Arun District Council
Development Control
1, Arun Civic Centre Maltravers Road
Littlehampton
West Sussex
BN17 5LF

Our ref: HA/2017/119951/01-L01
Your ref: FP/268/17/PL
Date: 07 December 2017

DETACHED 9NO. BEDROOM ANNEXE FOR BEACHCROFT HOTEL WITH 9NO. CAR PARKING SPACES.

BOAT POUND BETWEEN GREENOCK VILLA & THE GUNPOINT, CLYDE ROAD, FELPHAM, PO22 7AH

PROJECT Gull Point Suites - On the Beach
TITLE Typical Sections
SCALE 1 : 100
DATE 20/09/17
DRG NO IBA/480/09
REVISIONS

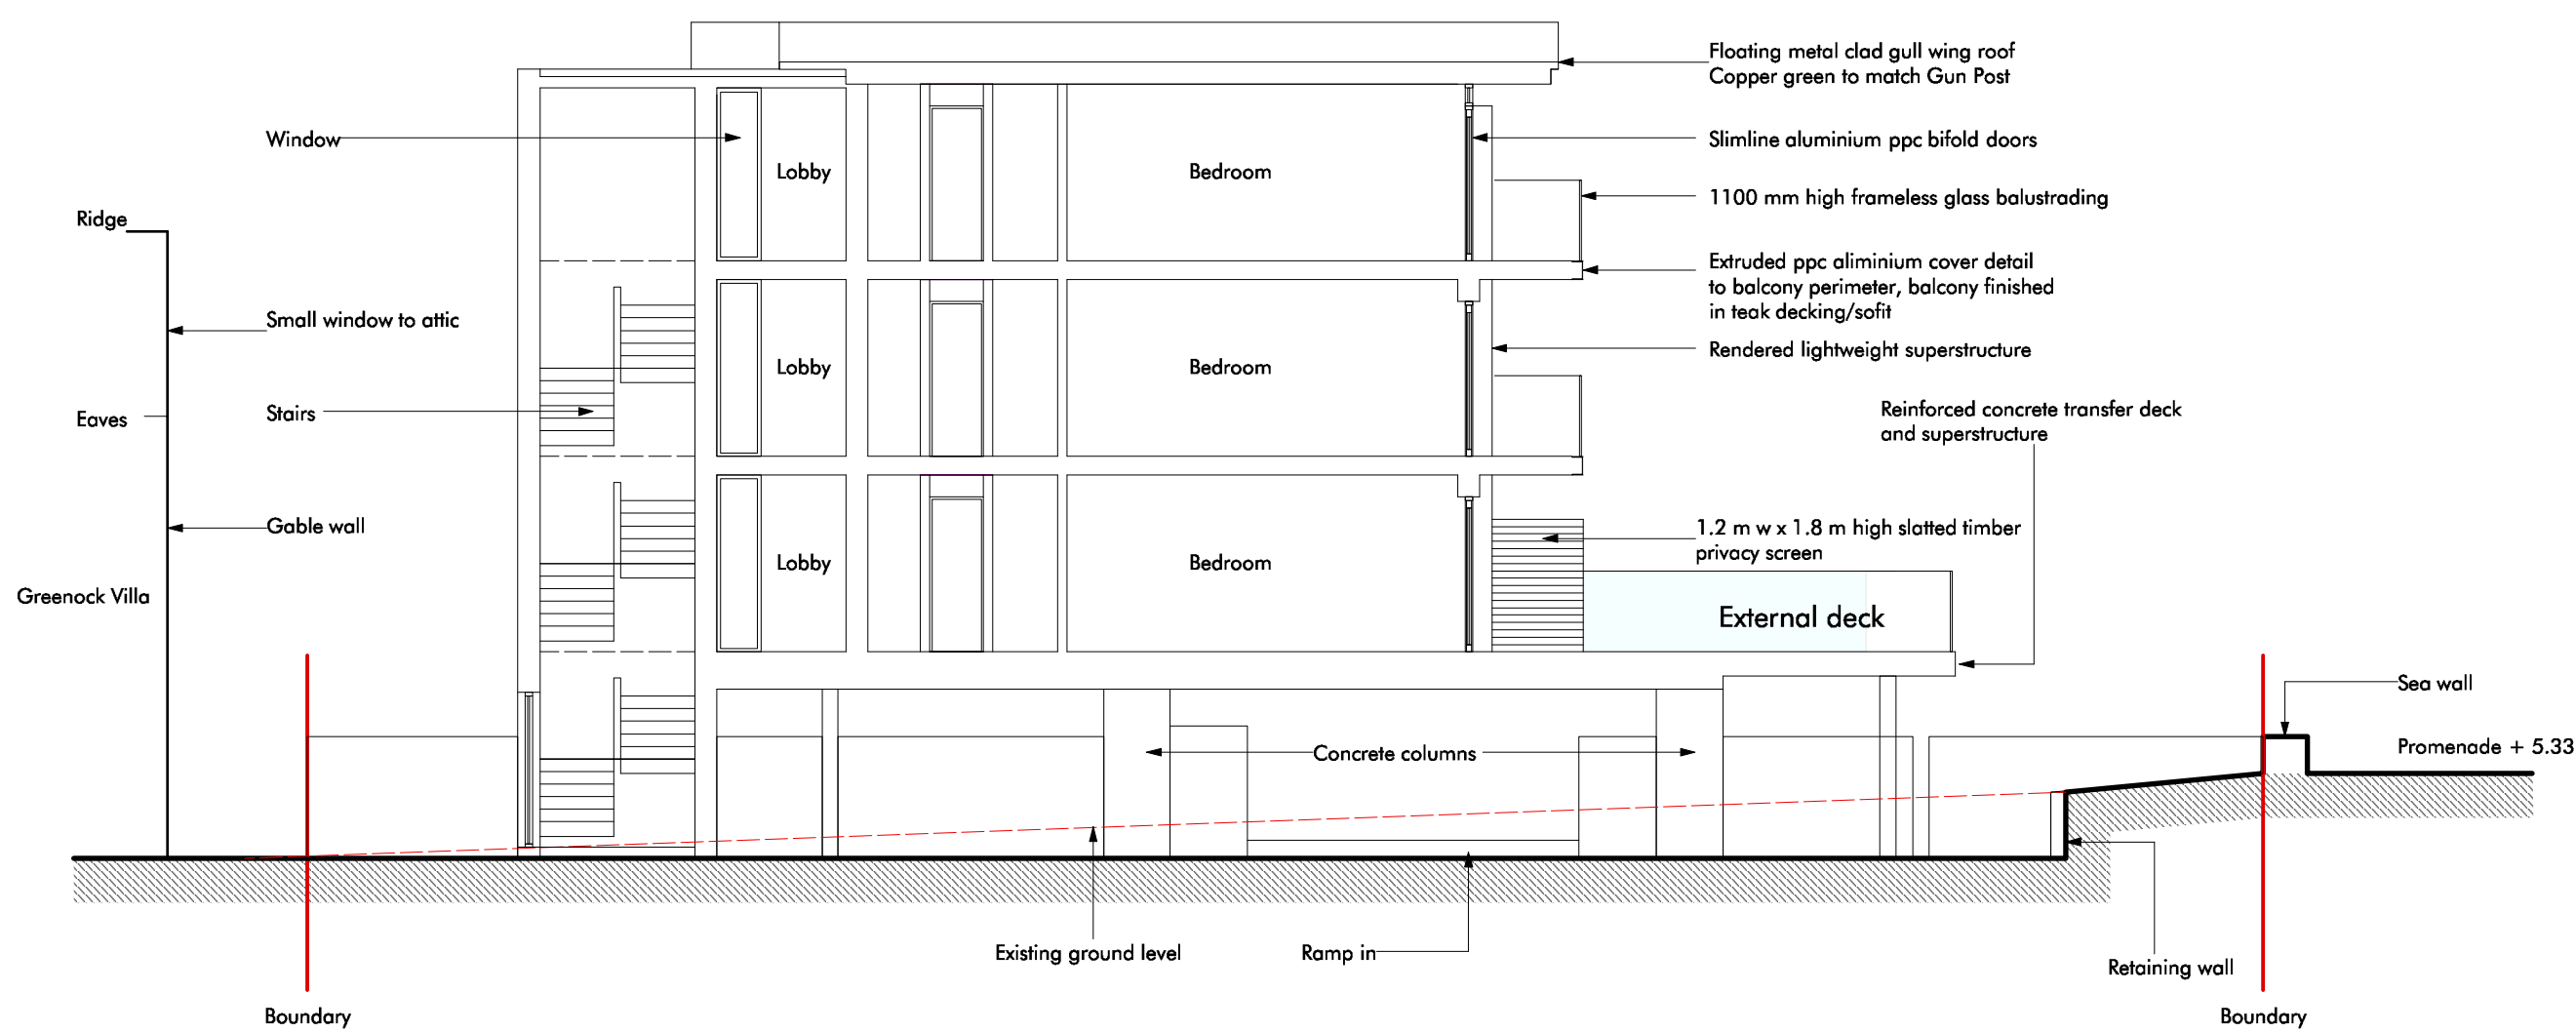
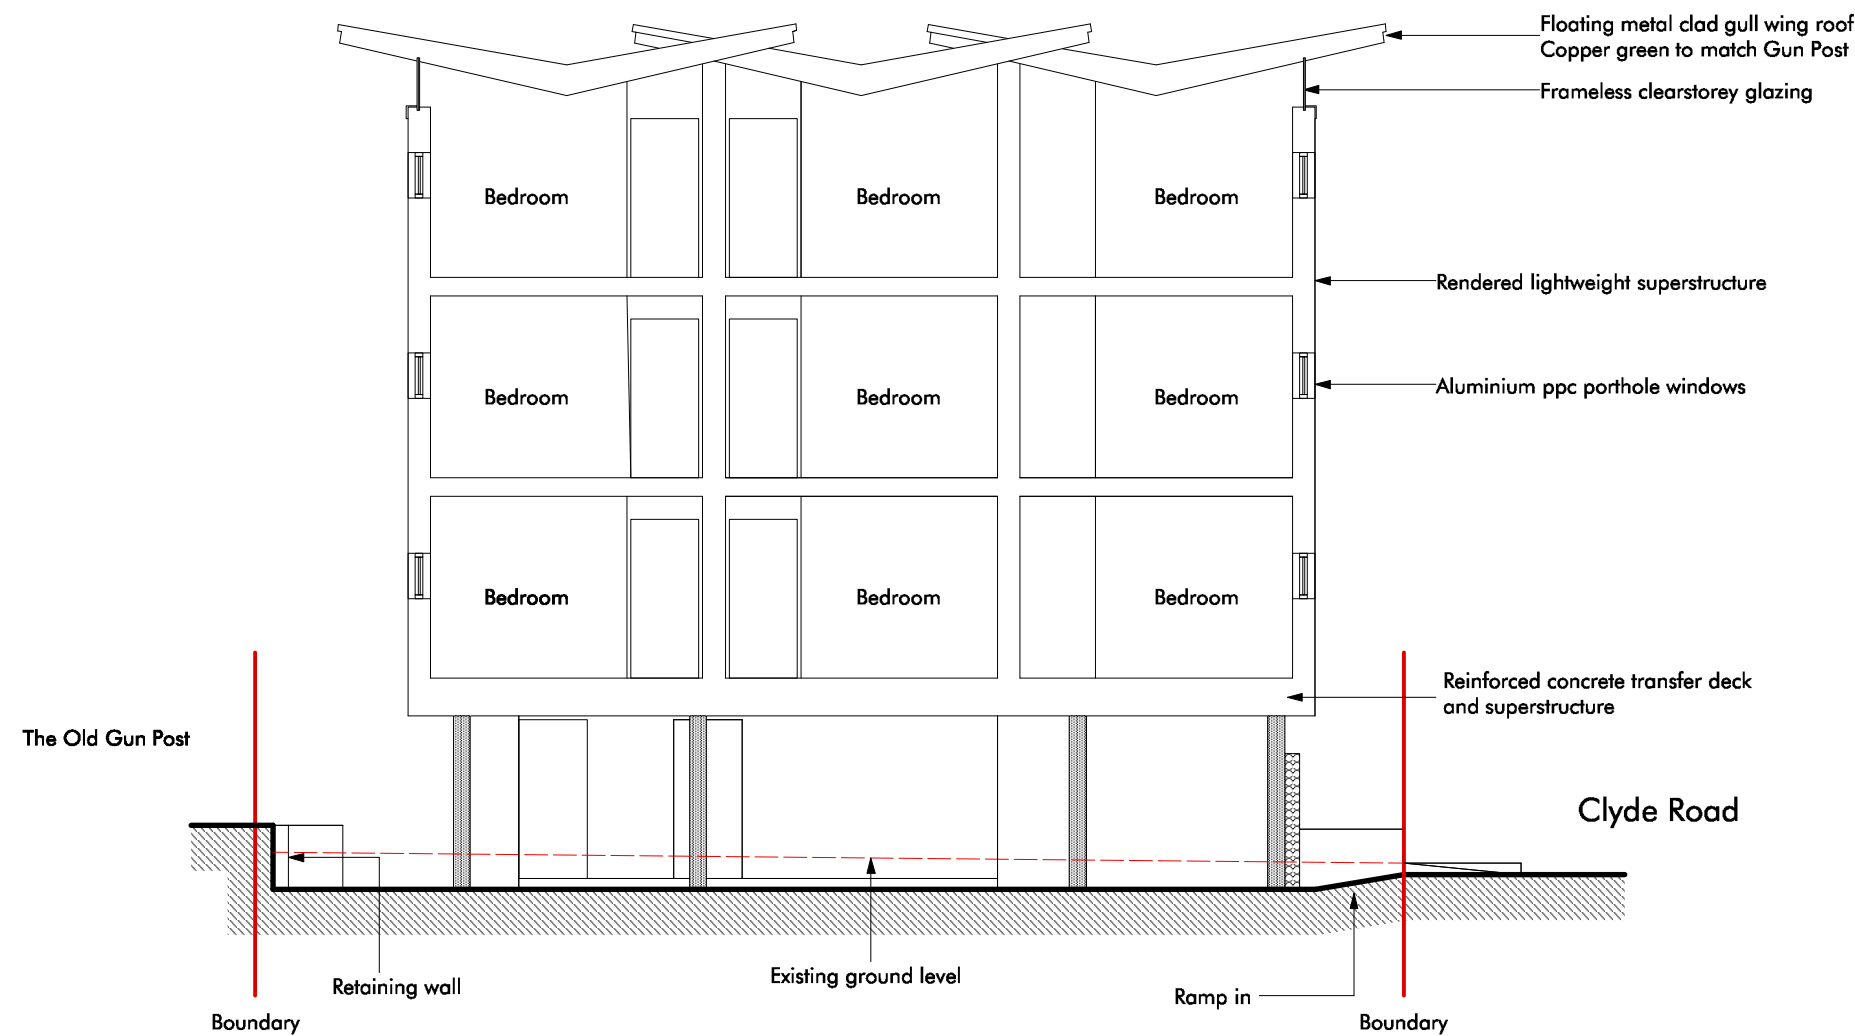
- **Finished floor levels for the first floor are set no lower than 6.95 metres above Ordnance Datum (AOD).**
